WELWYN HATFIELD COUNCIL – DEVELOPMENT CONTROL
DELEGATED REPORT

APPLICATION No:	S6/2011/1397/FP
------------------------	------------------------

The proposed development would involve an extension to the northern flank wall of the dwelling. The proposal would measure 7.74m in depth by 2.86m in width and would adjoin the main roof to create a gable end with a new chimney. The application also involves the demolition of a garage to reduce some of the built development within the application site.

CLIENT **Mr & Mrs Cumberland**
LOCATION/PROJECT
Stocks, Lysley Place, Brooksmans Park,
Hatfield, Hertfordshire, AL9 6NZ
TITLE OF DRAWING
Proposed Ground Floor Plan & Elevations

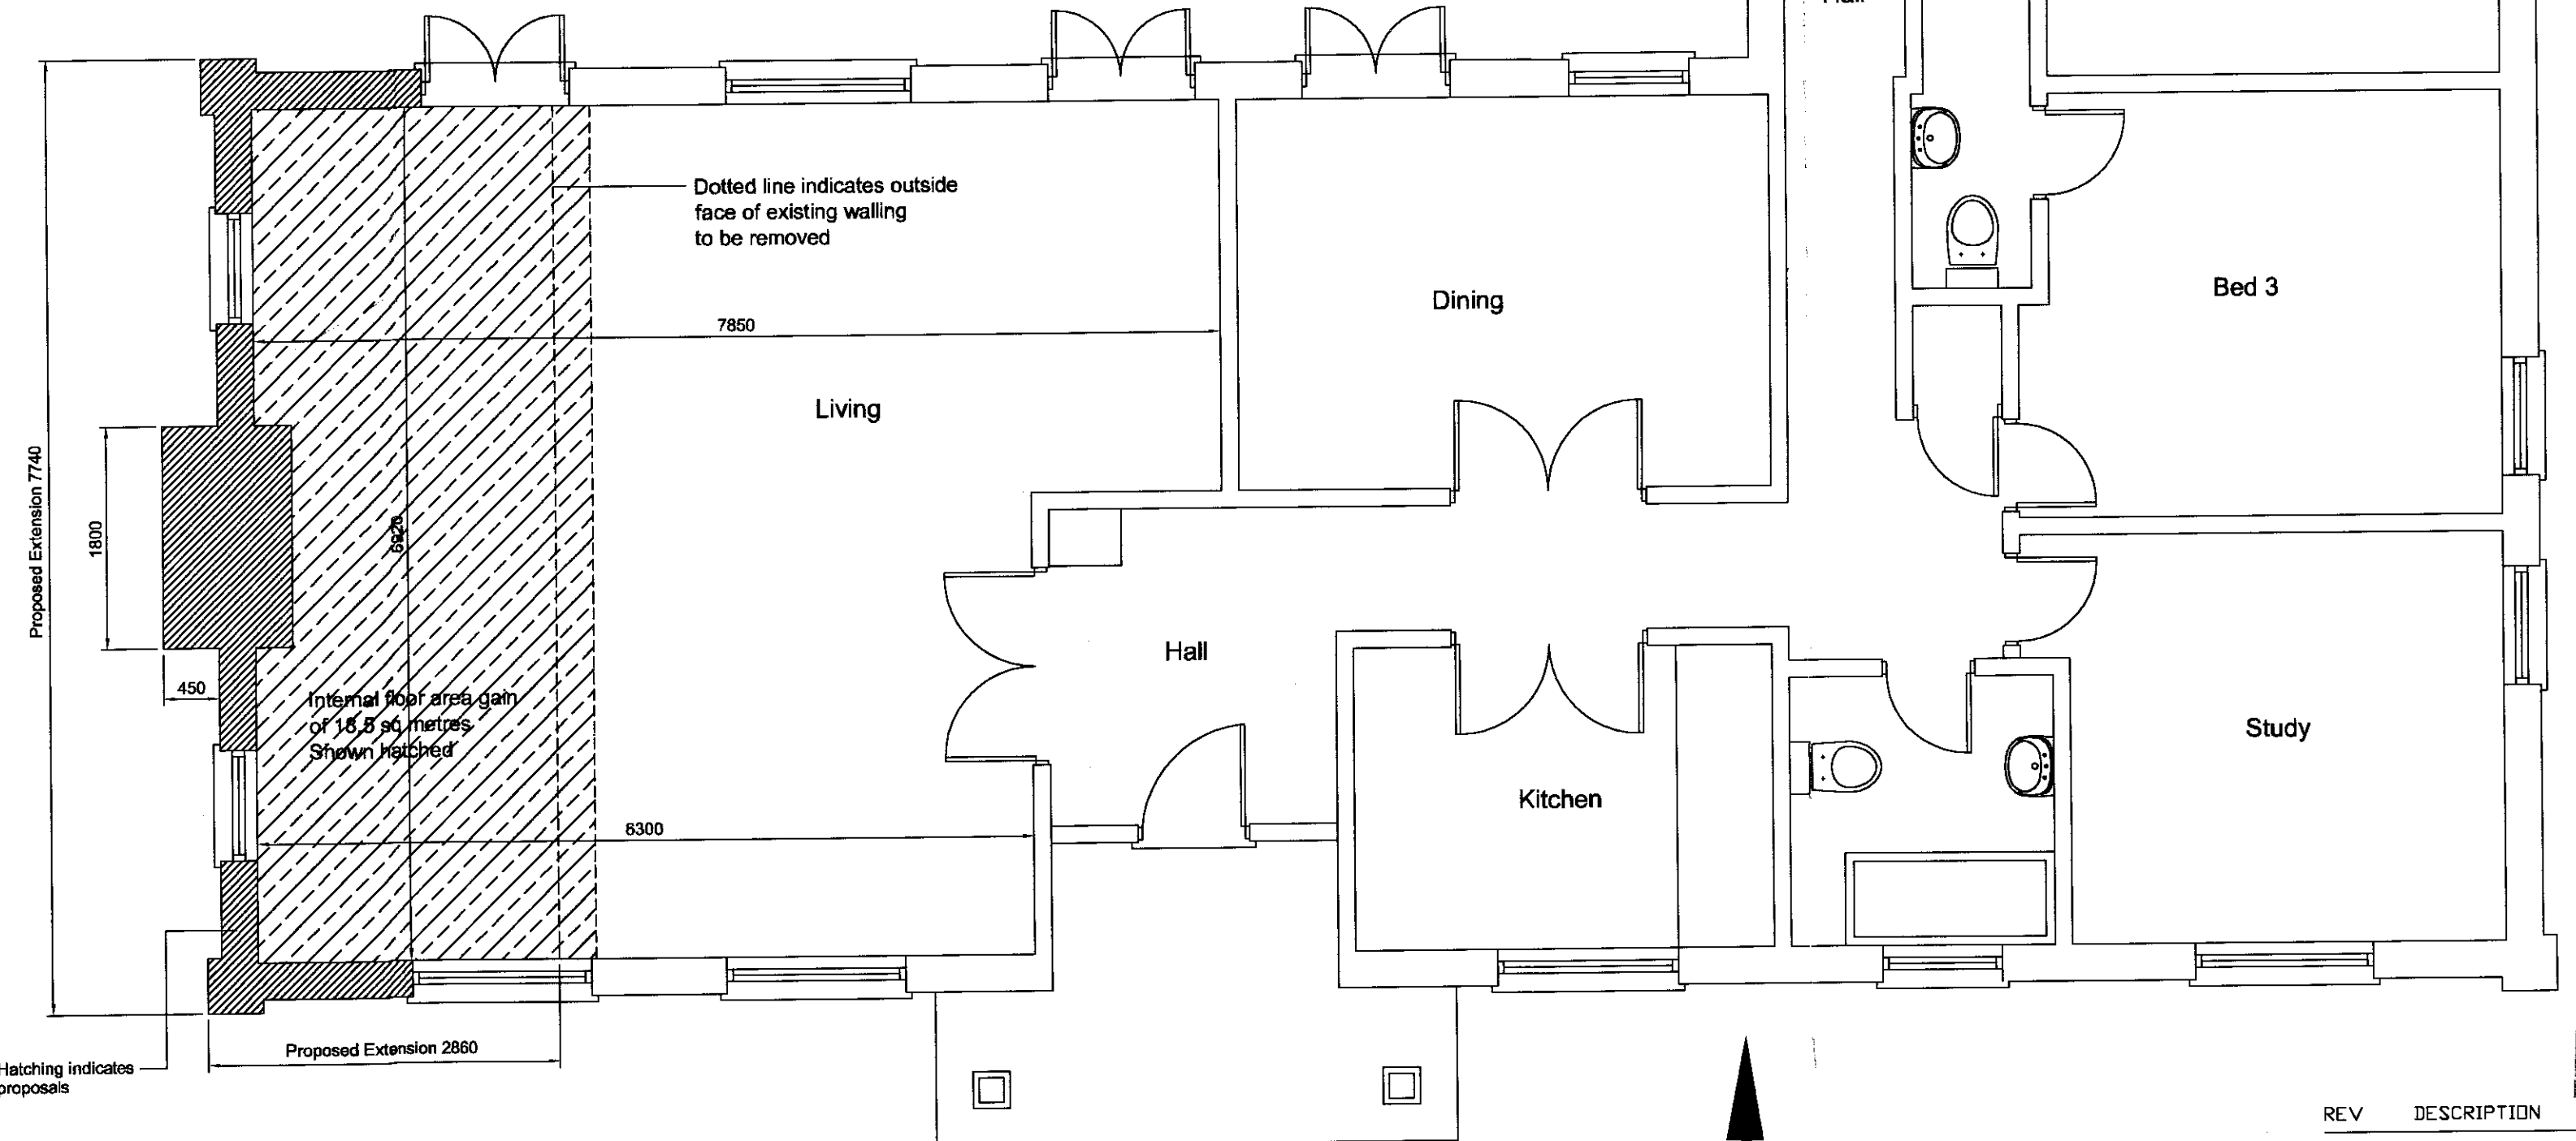
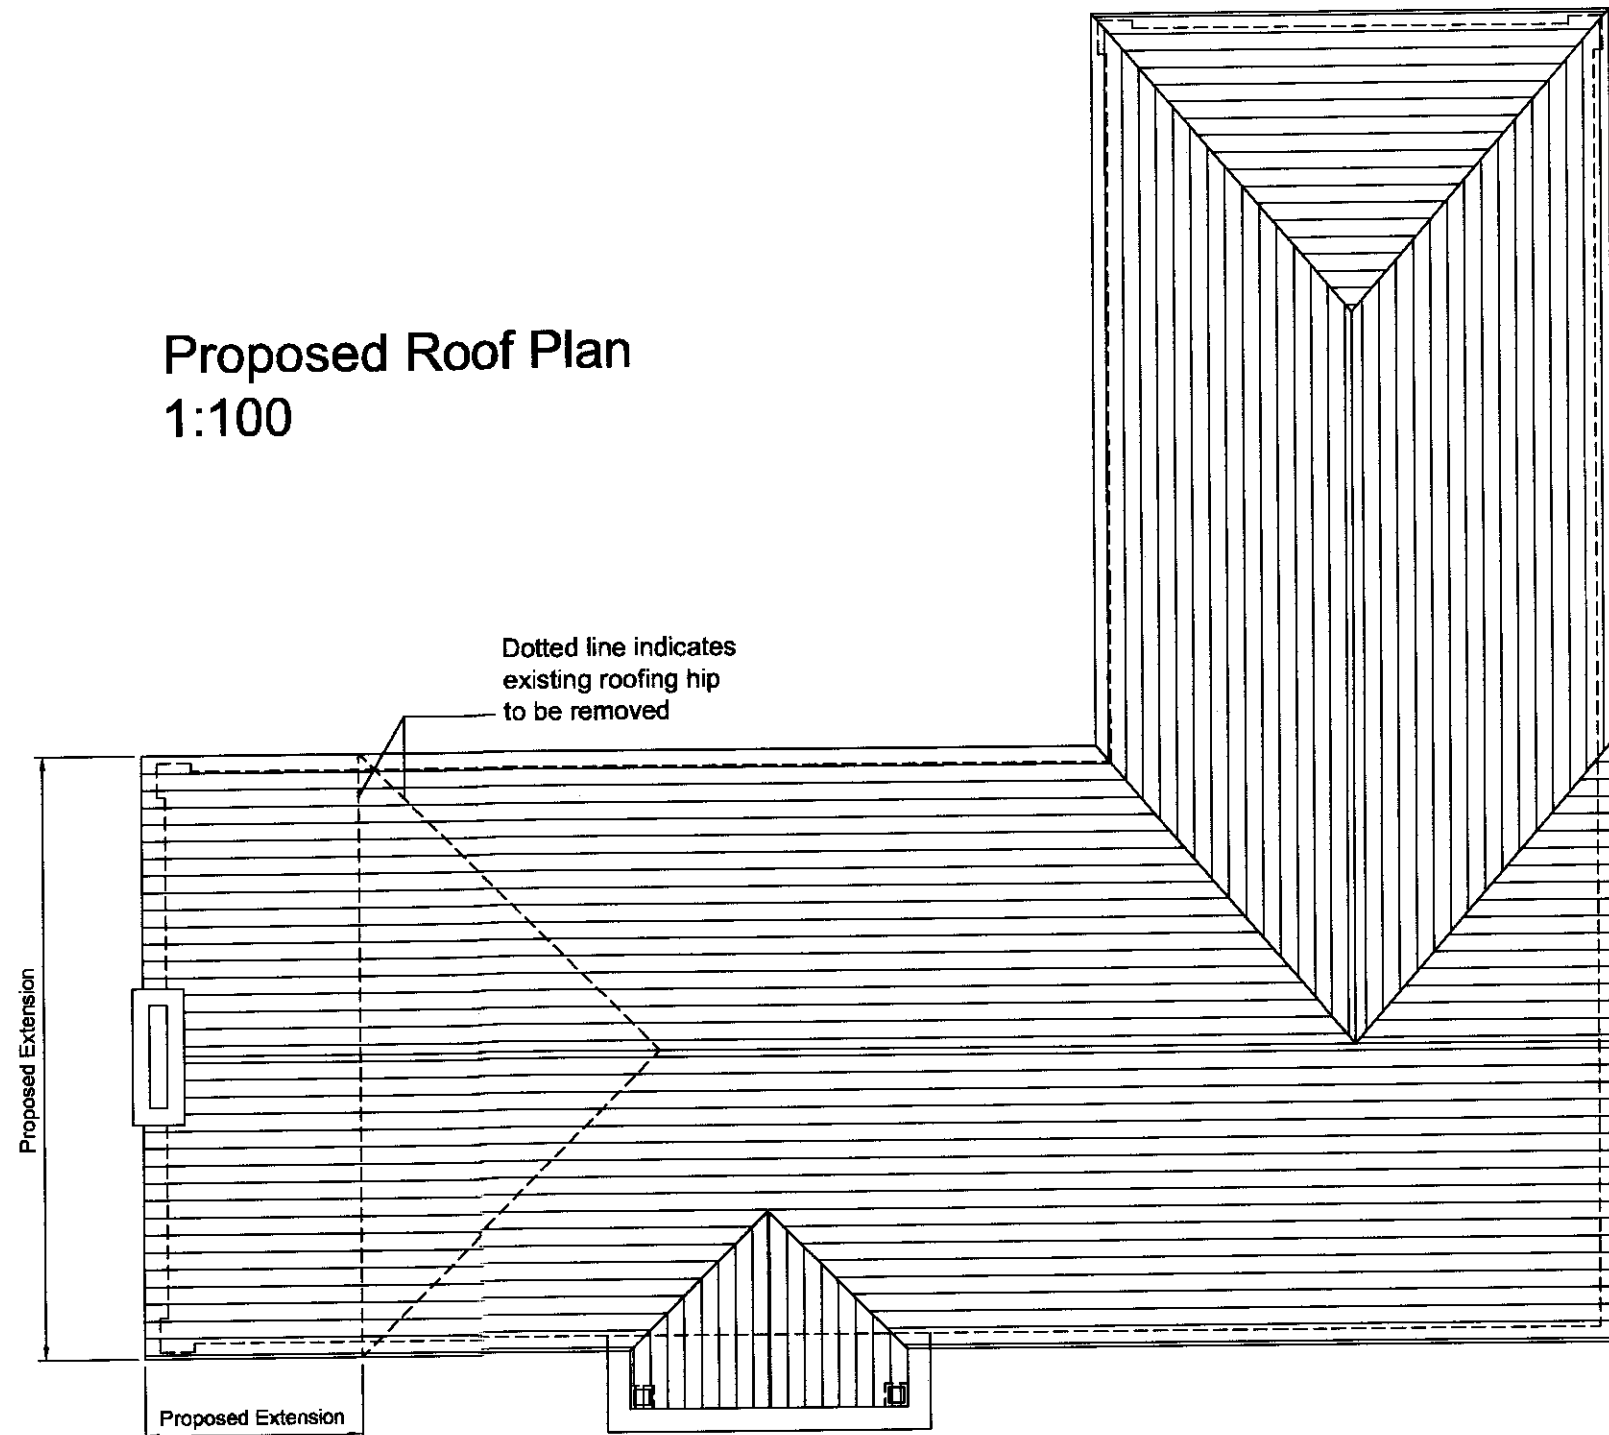
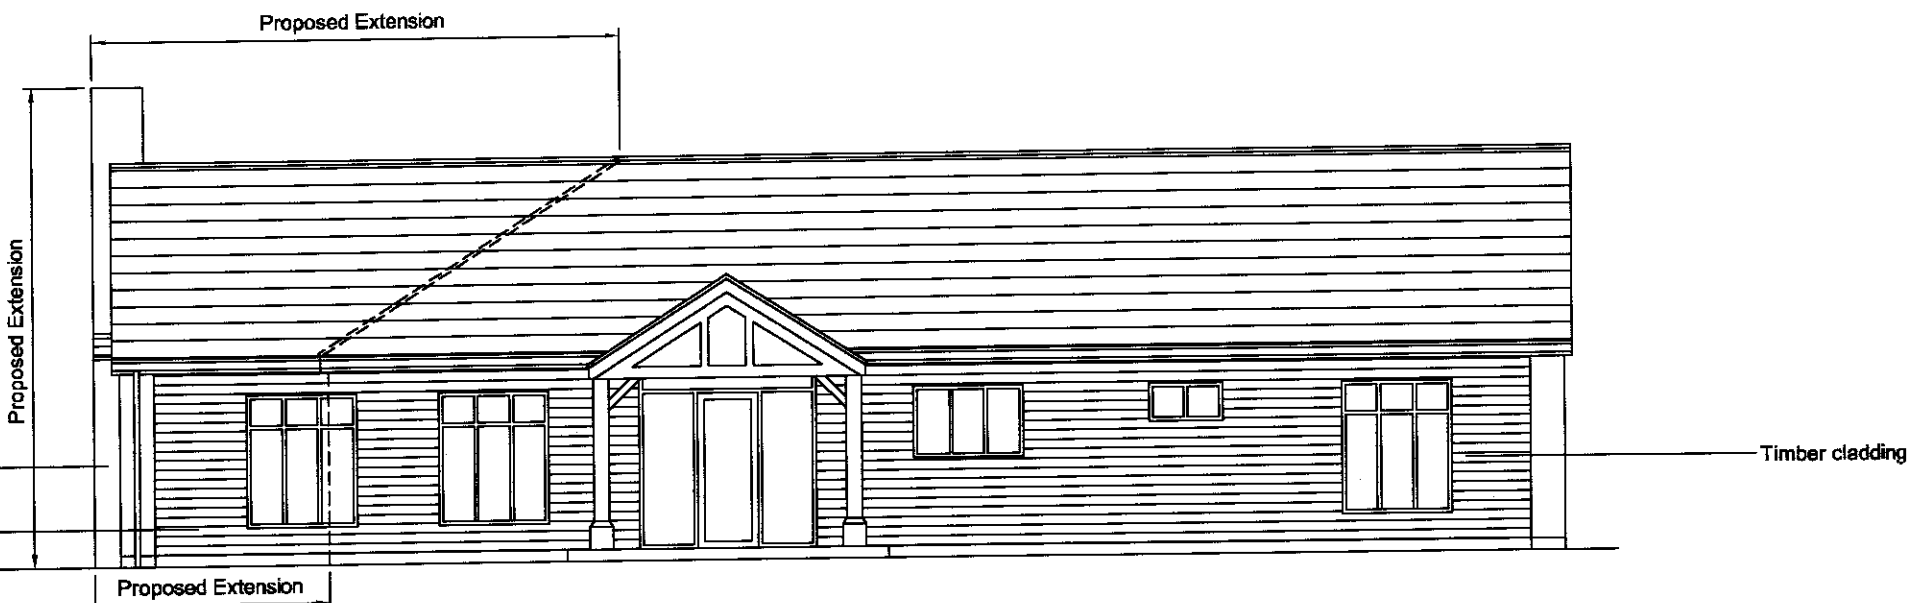
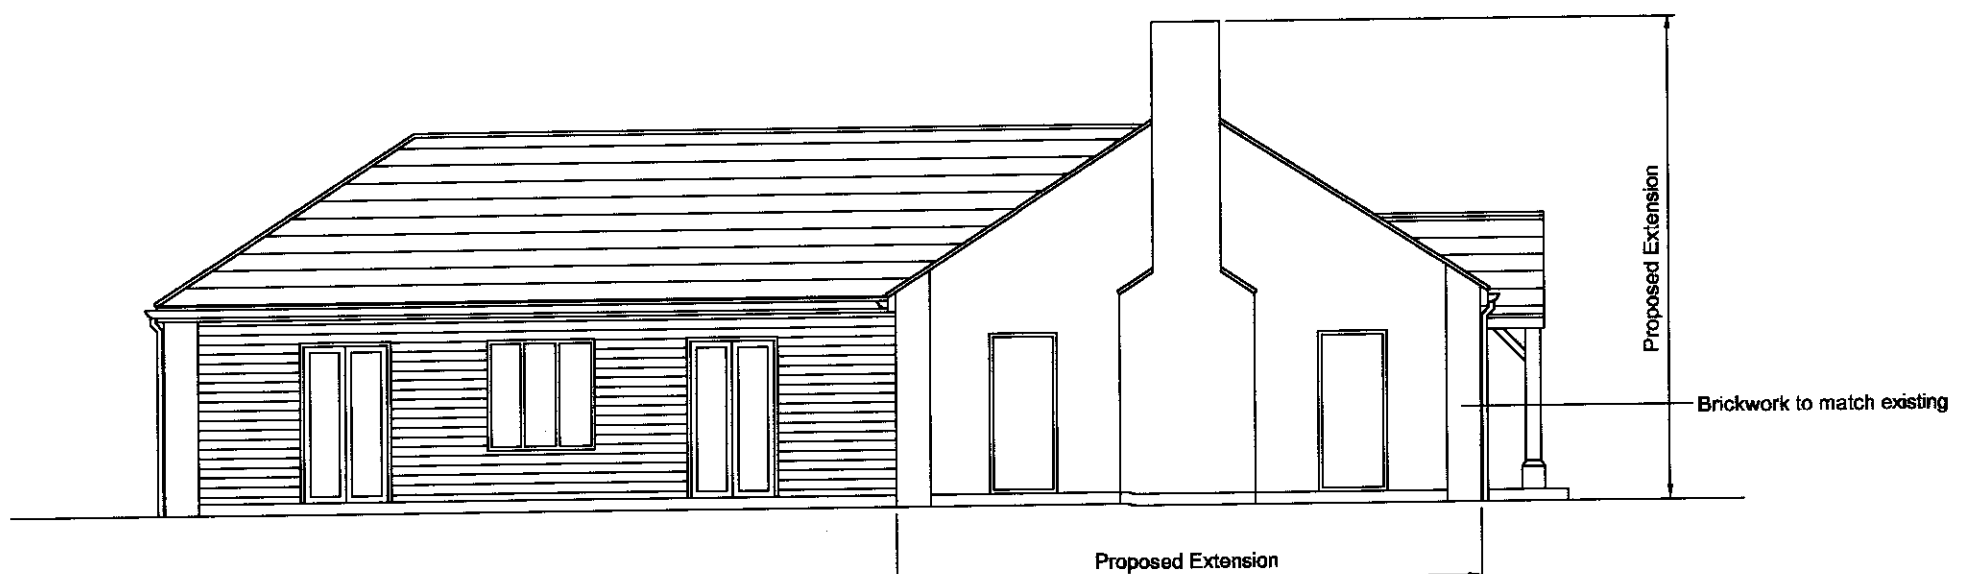
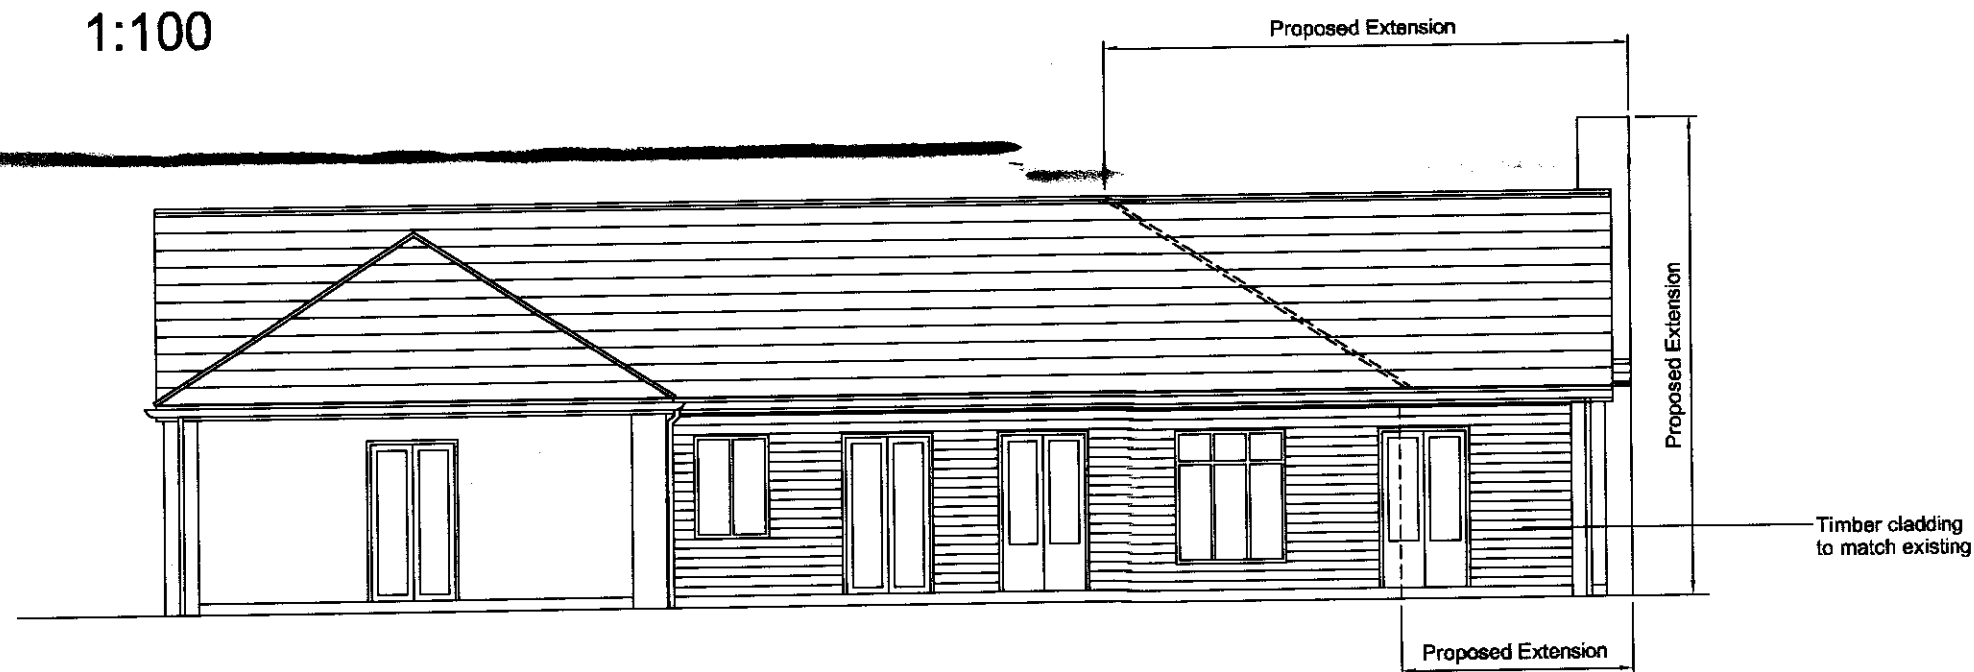
The application dwelling has been previously extended significantly, with an extension which has added roughly 63sq.m. The original dwelling had a floorspace of 116sq.m and therefore the property's floorspace has been increased by approximately 54% as existing. The proposed development would have a floor area of 22.1sq.m and the resultant dwelling would have a floorspace of 202.5sq.m. Therefore, the resultant increase in floorspace would equate to 74.6% when compared to the original dwelling.

When viewed individually the proposed extension's projection and floor area would be subordinate in scale and would attach well of the existing dwelling. The proposed chimney and gable end would add to the bulk and mass of the dwelling and this would be a large increase when compared to the original dwelling. From a design point of view the resultant dwelling would not be significantly more harmful than the existing dwelling. Due to the siting of the dwelling the proposed extensions would not be viewed prominently or appear dominant from the surrounding public areas and the resultant dwelling would not have a significantly greater impact upon the visual amenity of the area. Therefore, although the proposal would increase the bulk and massing of the property which conflicts with Policy RA3(i), the appearance and quality of design and appearance of the proposal would not conflict with the requirements of design Polices D1 and D2 of the Welwyn Hatfield District Plan 2005.
